# MONA OFFSHORE WIND PROJECT

## Notification of Intention to Submit a Change Request Application

Document Reference: S\_CR\_1

**Notification of the Applicant’s intention to submit requests for changes**

Drawing Title:
STREET WORKS AND ACCESS TO WORKS PLANS - SHEET 11

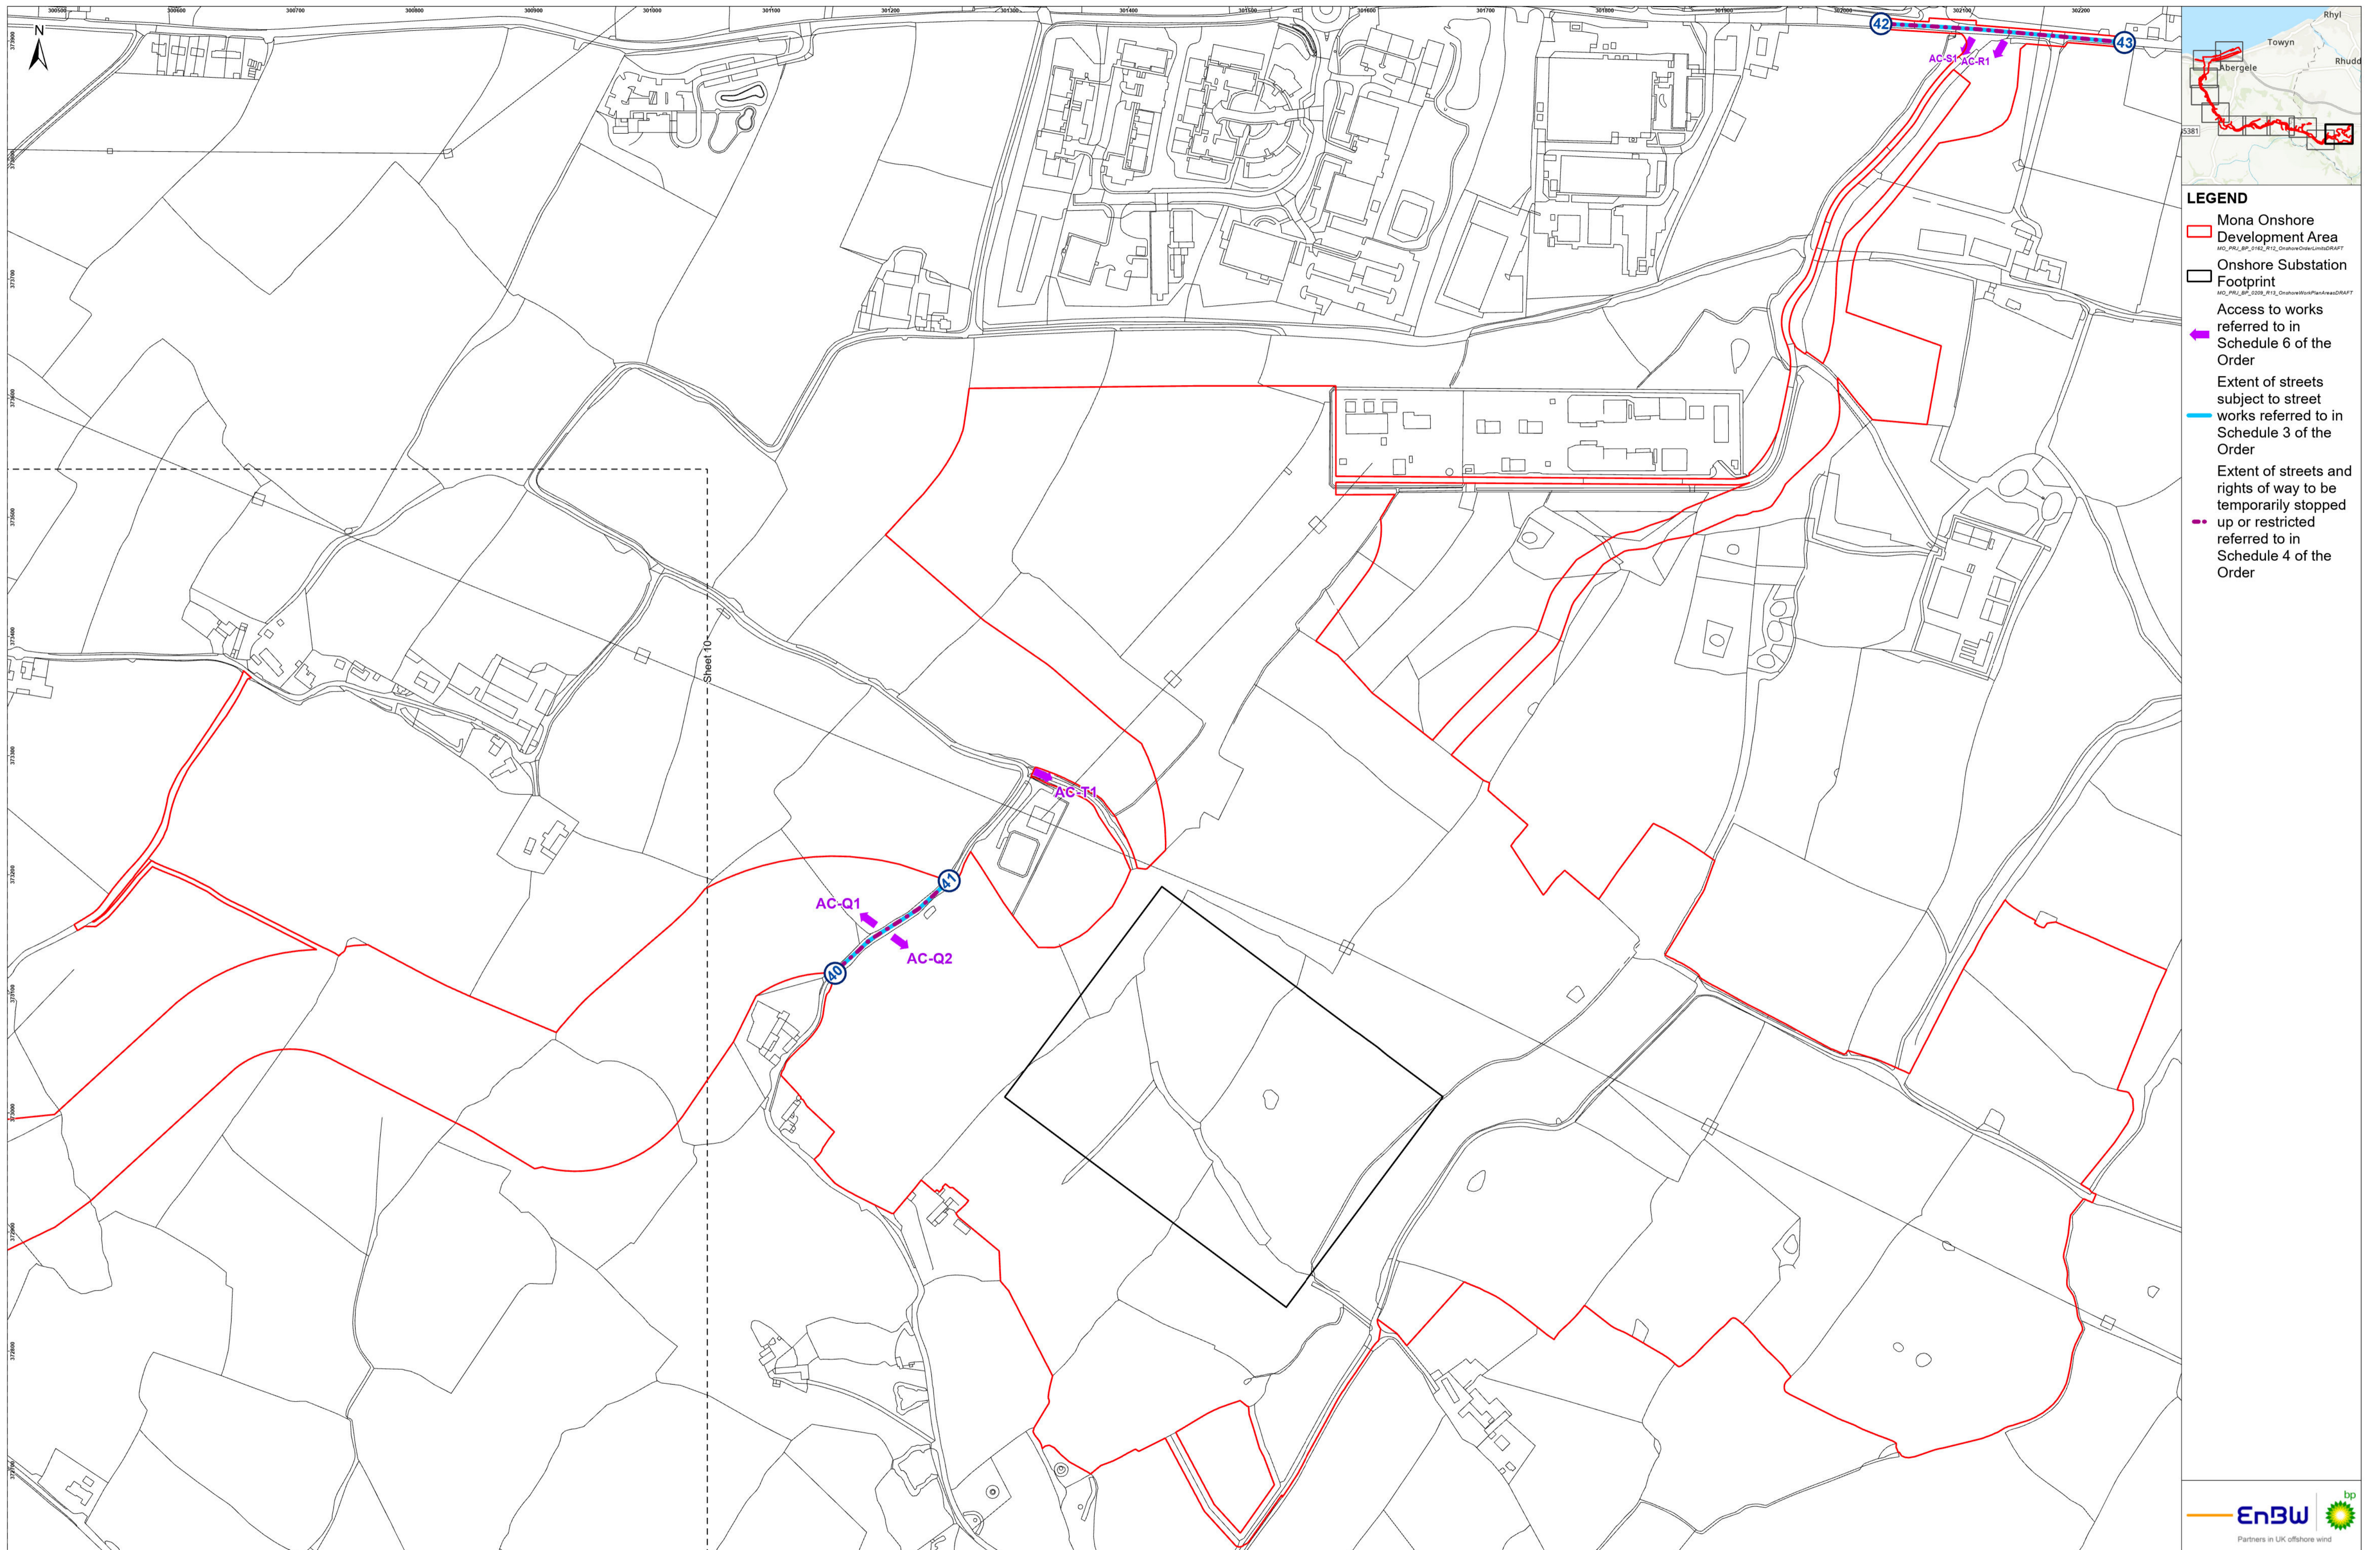
It is therefore necessary to extend the Order Limits and Work No.27 in this area to accommodate the safe access and egress of AILs as well as to accommodate the swept path for the access through the proposed bellmouth junction (see Sheet 11 of Street Works and Access to Works Plan (AS-008)).

Change 1a – Order Limits change to include an existing access track to the west of the onshore substation for temporary access during onshore site preparation works

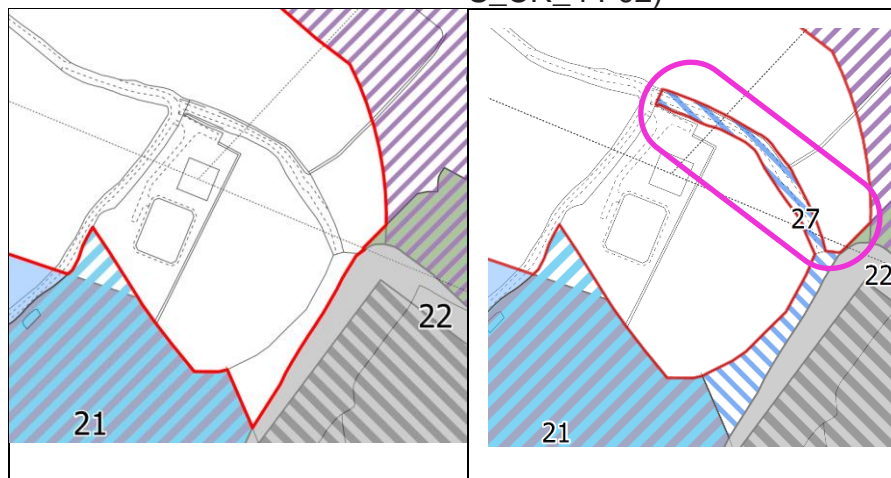
Change 1a – Order Limits change to include an existing access track to the west of the onshore substation for temporary construction access during onshore site preparation works and construction of the onshore substation and surrounding works

It is proposed to include a section of the existing access track at the onshore substation at grid reference SJ 01353 73277 within the Order Limits to accommodate temporary construction access.

This existing access track is currently being utilised by the Applicant for ongoing site survey and investigation works. No works or upgrades to the existing track are proposed, it is simply proposed to use the track to take access to Work Nos. 21, 22 and 31 (and other works areas adjacent to Work Nos. 21, 22 and 31).

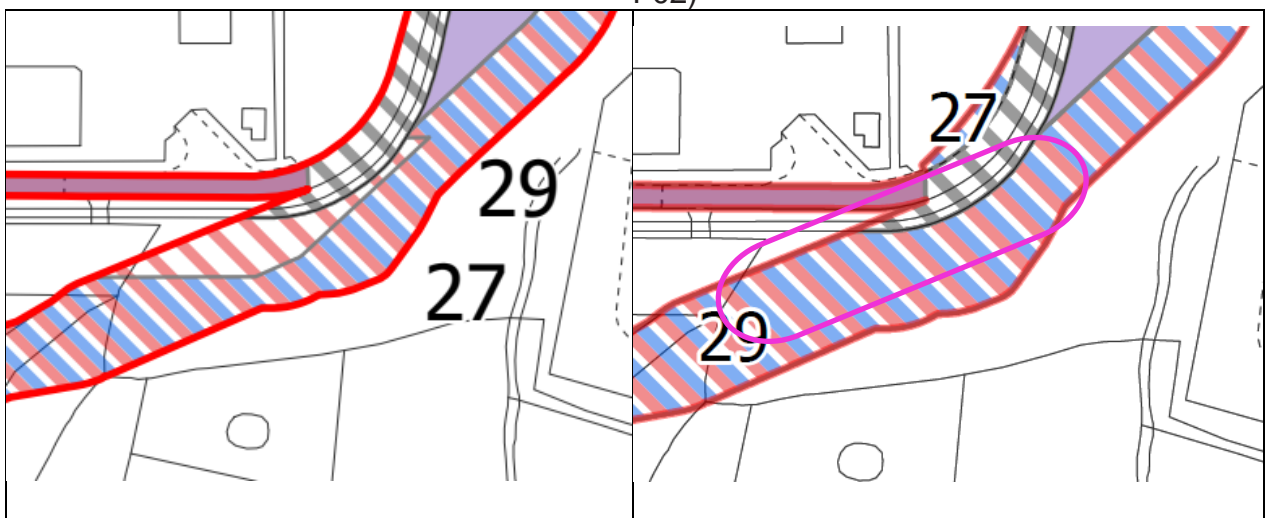
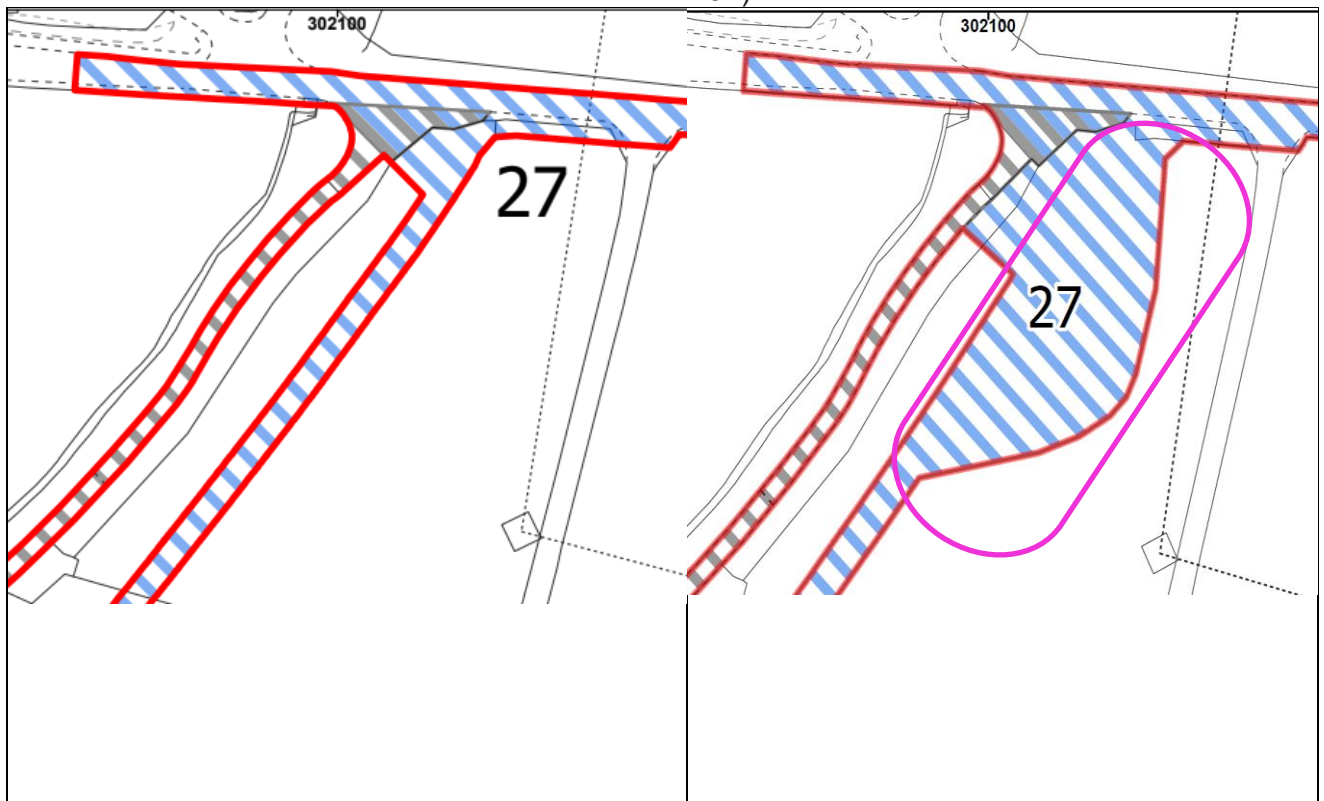
Change 2a - Order Limits change to widen the temporary onshore substation construction access road and bellmouth, which follows the alignment of the construction access road previously used by the Gwynt y Môr and Burbo Bank Extension Offshore Wind Projects during their construction, at grid reference SJ 01936 73552 (Work No. 27 on the Works Plans – Onshore (AS-003)).

Change 2b – Amendment to Work No.27 to widen the temporary onshore substation construction access road at grid reference SJ 01911 735518 by including a small area of additional land to the area identified for Work No. 27 (approximately 538m<sup>2</sup>) within the existing Order Limits. This land is currently identified as part of the permanent onshore substation access (Work No. 29) only.

The additional area of land required outside the existing Order Limits for Change 2a amounts to approximately 1212m<sup>2</sup>. Whilst this was included within the boundary of the PEIR published in April 2023, the Applicant's preliminary design works indicated that this land would not be required and it was removed prior to submission of the Application in an effort to reduce land take. However, as part of the Applicant's early detailed design works and investigations into the swept path for the delivery of AILs to the Mona Offshore Wind Project onshore substation, in particular the large transformers required for the substation, it has been identified that additional space at the bellmouth is required in order to make the turning into the onshore substation temporary access road safe. The work has also identified additional space is needed along the temporary construction access road to facilitate the AIL's whilst ensuring adequate space for the fencing requirements outlined in the outline Fencing Management Plan (REP2-048).

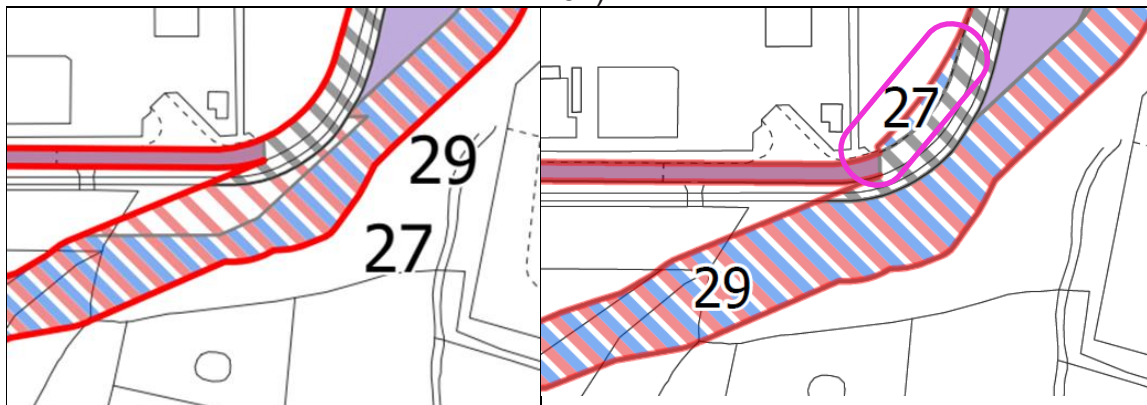
It is proposed to widen the temporary onshore substation construction access road eastward to accommodate an additional temporary Sustainable Urban Drainage System (SuDS) attenuation pond at the northern extent of the onshore substation construction access road.

The additional area of land required for Change 3 amounts to approximately 2350m<sup>2</sup>. Whilst this land was included within the boundary of the PEIR published in April 2023, it was not included upon submission on the basis of the preliminary designs for the onshore substation construction access road. However, the Applicant's early detailed design works for the onshore substation construction access road, including the swept path analysis outlined in Change 2, has identified the need for additional land take. This is in order to deliver attenuation to control the discharge of surface water during construction, in part due to the wider road outlined in Change 2, and also from the requirement for GCN fencing to be deployed, likely resulting in additional drainage pathways. It is proposed to construct a temporary SuDS attenuation basin as a measure to control this additional surface water runoff. The Proposed Change 3 will result in a controlled surface water discharge into an existing drainage channel, reducing the risk of increased flooding downstream.
